February 5, 2016

**Re: Juan Tabo Hills Estates Preliminary Plat, DRB# 1005278**

Attached please find a revised Grading Plan, Infrastructure list, and Preliminary Plat, Preliminary Bank Protection Design, Sidewalk Exhibit, Curb and Sidewalk Dimension Exhibit, and Conceptual Utility Plan incorporating revisions to address the comments received from AMAFCA on Feb 2, 2016, and the DRB on Feb 3, 2016. The comments have been addressed as described below in red.

**CURB & SIDEWALK
 DIMENSIONS EXHIBIT**

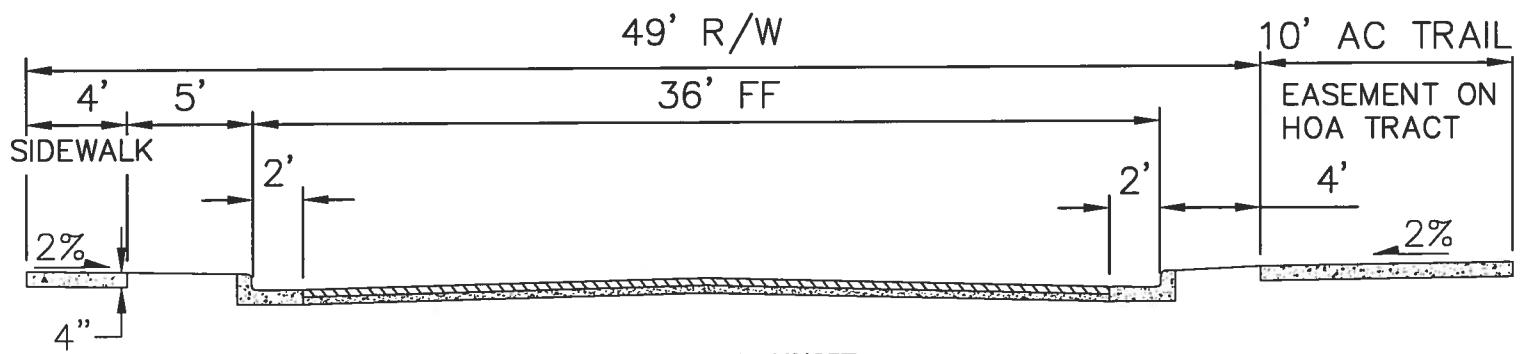
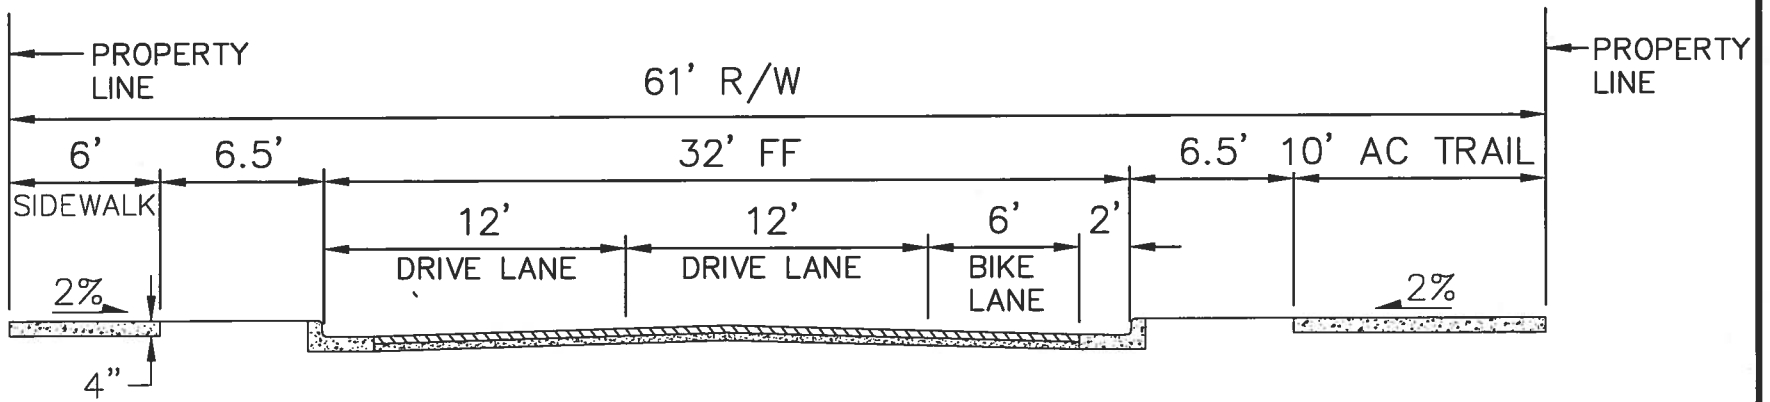
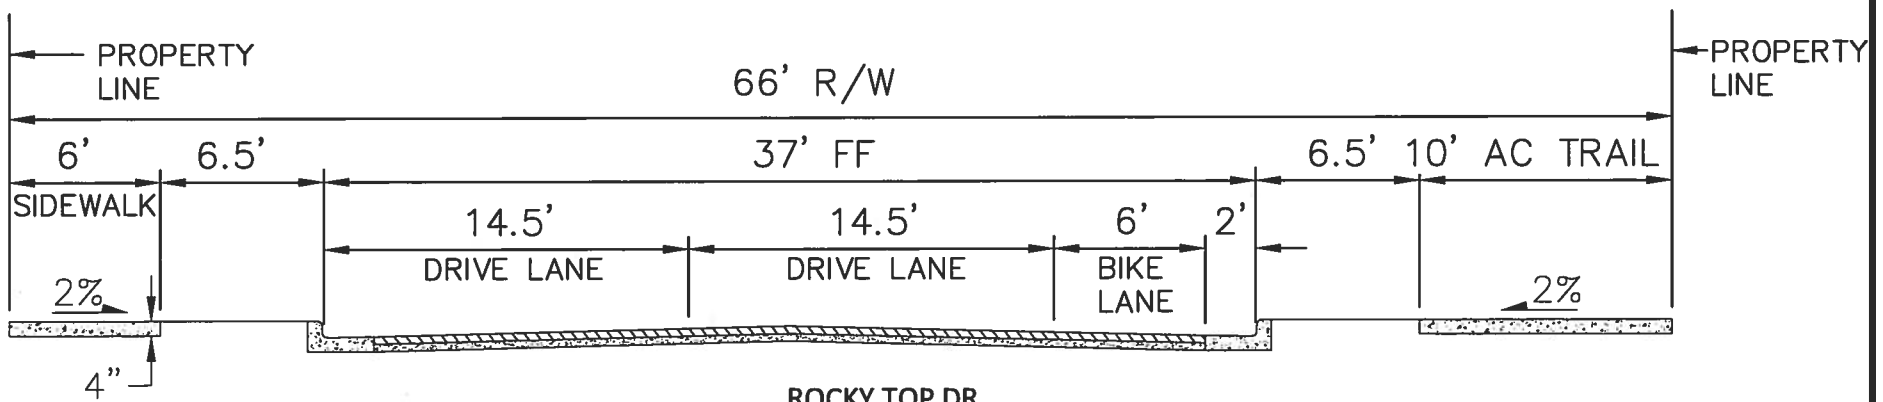
1. A couple of additional cross sections need to be added.
  - a. RW = 47' and F-F 26'
  - b. RIW = 47' and F-F = 28'

*The cross section at the end of the first page of the Curb and Sidewalk Dimensions Exhibit has been moved to the second page and expanded to show the full width of the Right of Way. The Conceptual Paving plan has also been provided to assist the review.*

JUAN TABO HILLS ESTATES - OCTOBER 2015
PRELIMINARY
TJERAS ARROYO BANK PROTECTION

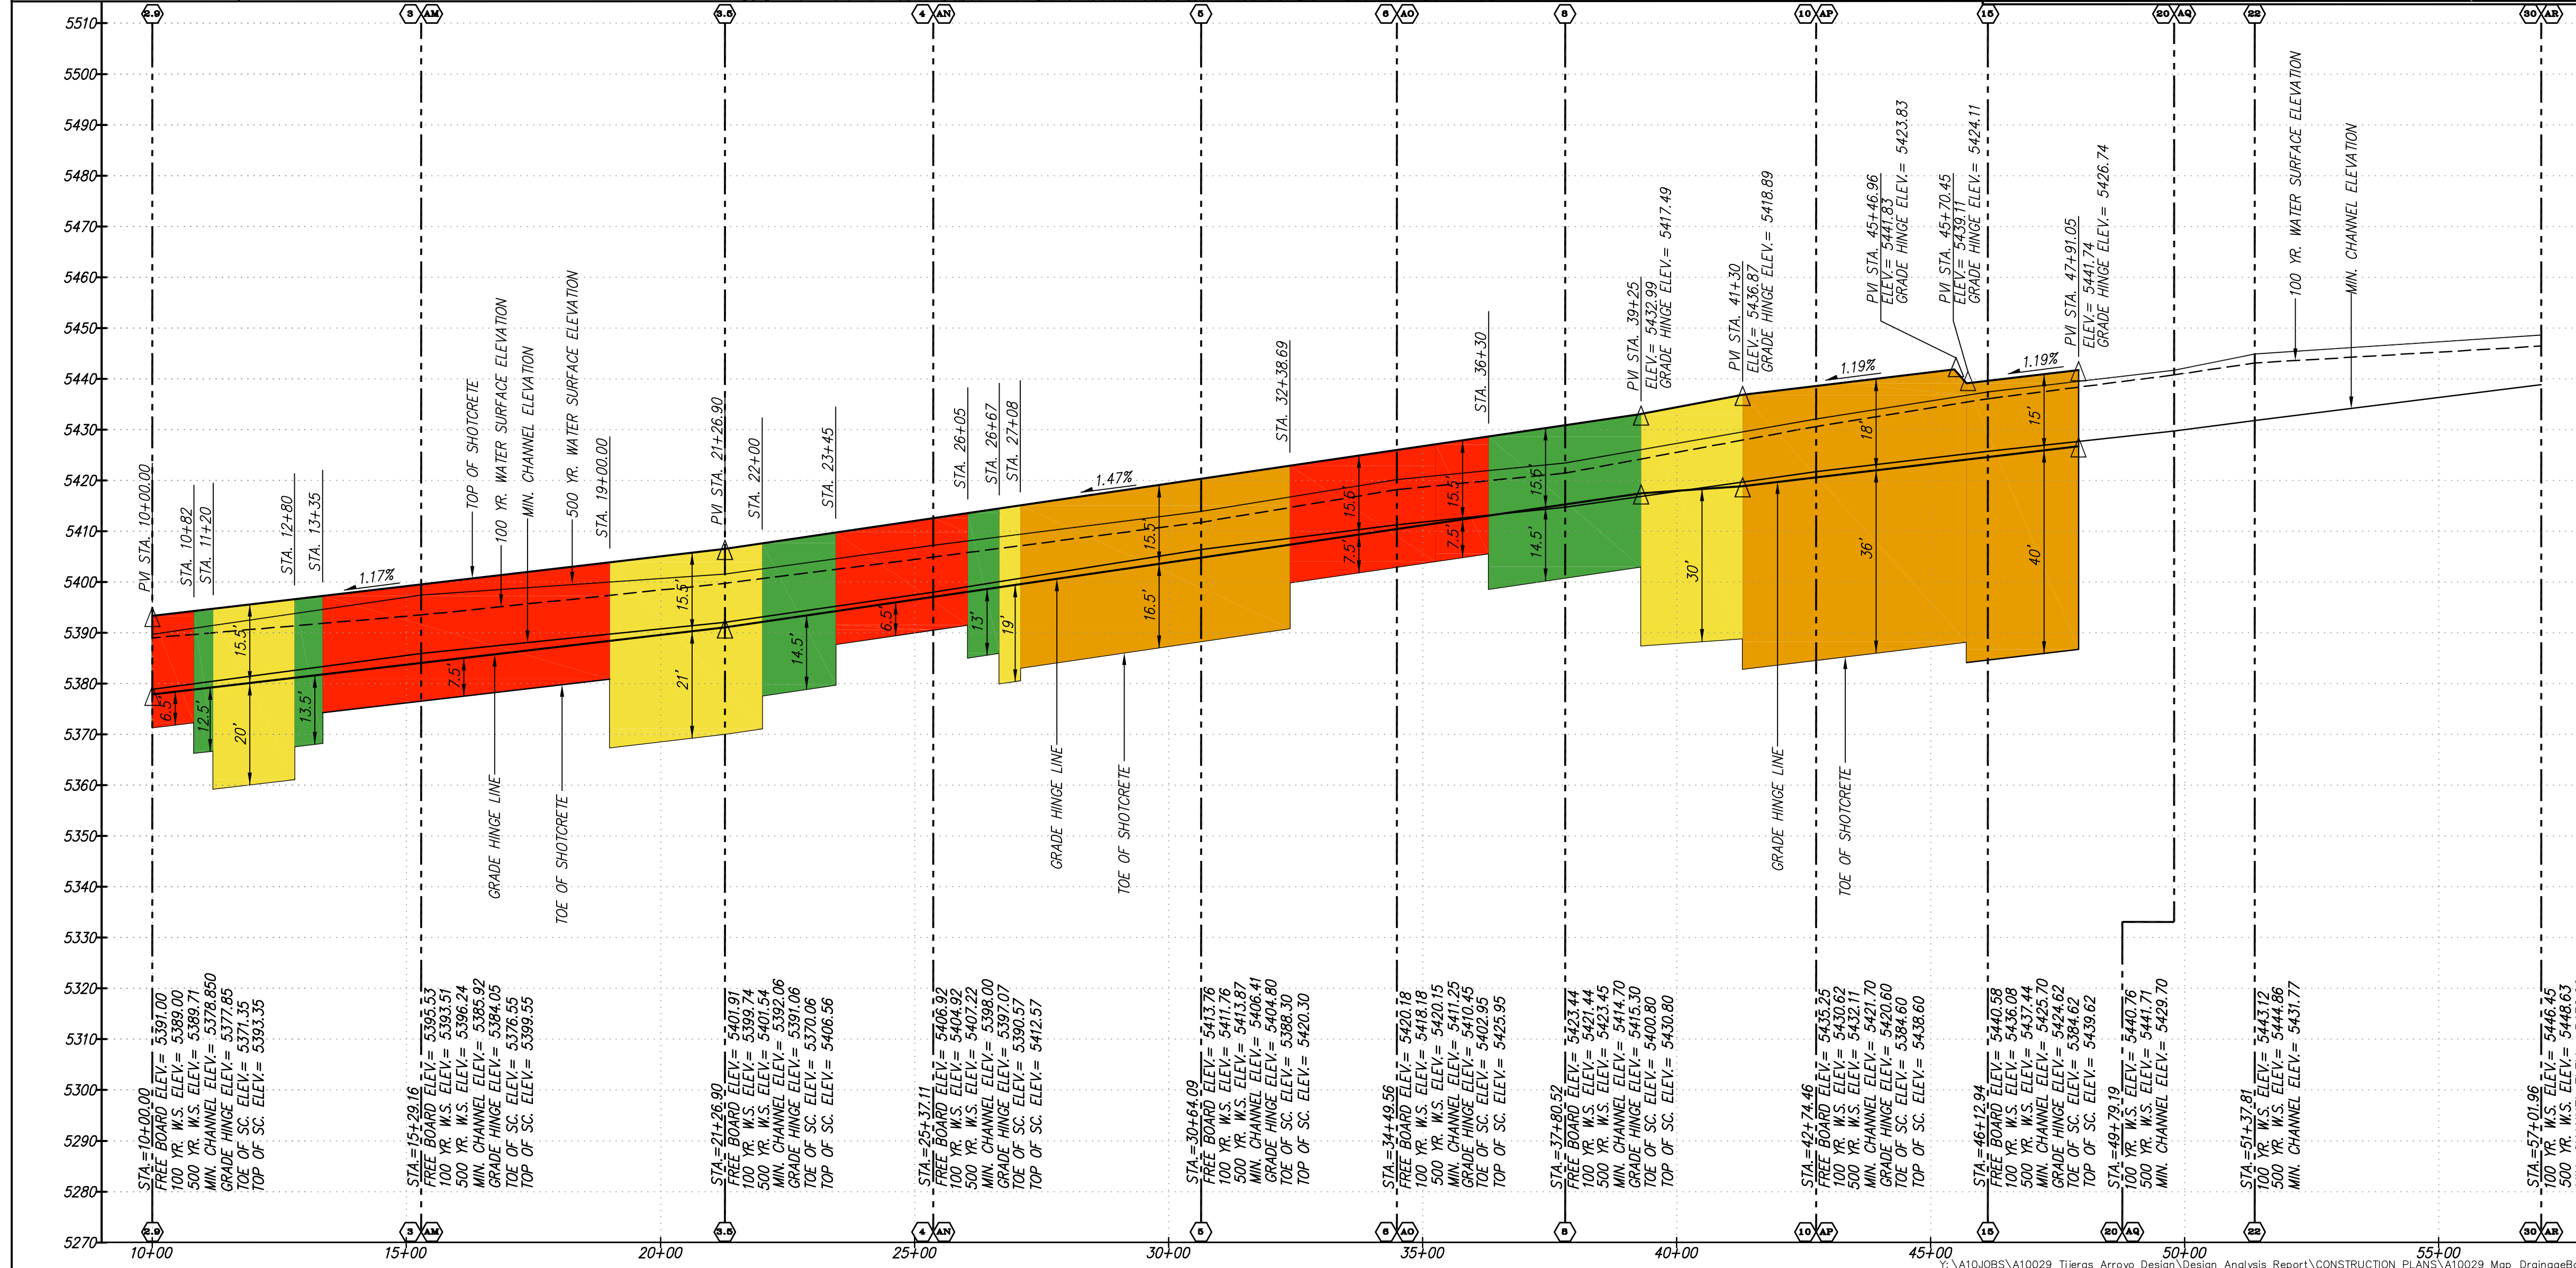
3. If the pond must stay in place, it will require a concrete emergency spillway designed to pass the entire 100-year flow. The spillway will tie into the bank stabilization, which will wrap around the northern end of the pond and tie into the existing embankment. **The existing pond will remain and continue to serve as a water quality feature to the extent that it was originally intended to serve that function. It will not be protected by the bank protection on the west, so a concrete spillway will not be added with this project.**

4. The below grade scour protection north of the City pond is not bank stabilization. It appears that its sole purpose is to protect the Water Utility Authority's sanitary sewer line. How deep is the sewer line? AMAFCA suggests putting a concrete cap over the line. Maintenance of the concrete cap will be the responsibility of the WUA. **The scour protection north of the City pond has been removed from these plans.**
